From: Anthony Baker
Sent: 16 August 2019 10:59
To: [REDACTED]ren Garner; Joe Russell-Wells
Cc: Michael Eastham; Akehurst, Steve; Guzman, Kenny De
Subject: RE: *EXTERNAL: RE: Felpham Fence Location

1. There doesn't seem to be a specification for the fence material. The fence shown in your earlier email chain (attachment 1) shows a fence that is netted with a fibre mesh; this will simply not be durable enough – it will get cut, burnt and generally abused; I would prefer the barrier to be a metal mesh.
2. The plan you have attached shows the fencing in the wrong place; the fencing, according to Condition 3 of FP/151/11 is “adjacent to the parking area”, not by the relief road.

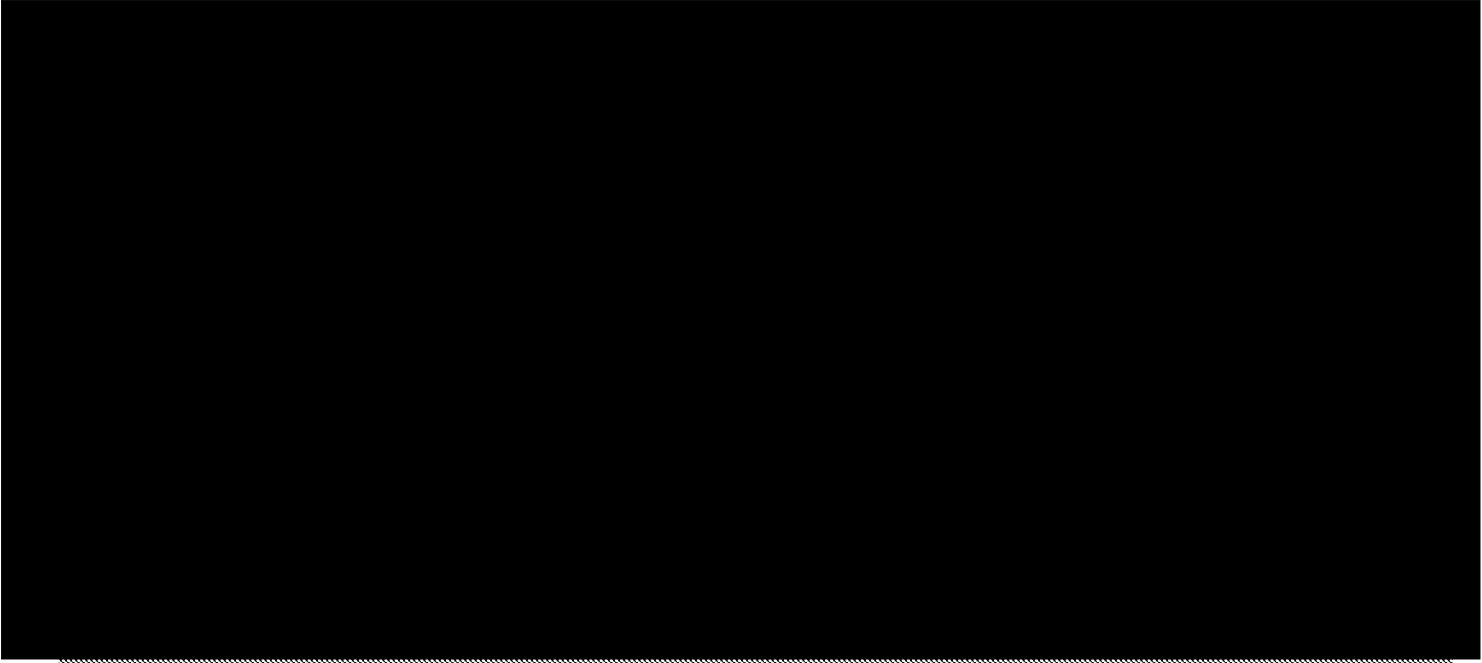
I hereby confirm the location of the football fence (ball stop fencing), as identified on the plan that you attached to your email (i.e. immediately north of the football pitch)

Can you please confirm the location of the football fence, I have attached a plan on which I have indicated the proposed location of a 3m high net fence. We discussed the location at the meeting and I'm sure what I have shown is what we discussed. Can you please confirm.

However, I observe that any agreement regarding the specification appears to have been made prior to a number of changes to the provision of recreation at this location (i.e. the construction of a MUGA and of a skate park). My senior colleagues are of the same opinion as I, that a netting ball-stop fence is wholly unsuitable and that a metal fence is more appropriate.
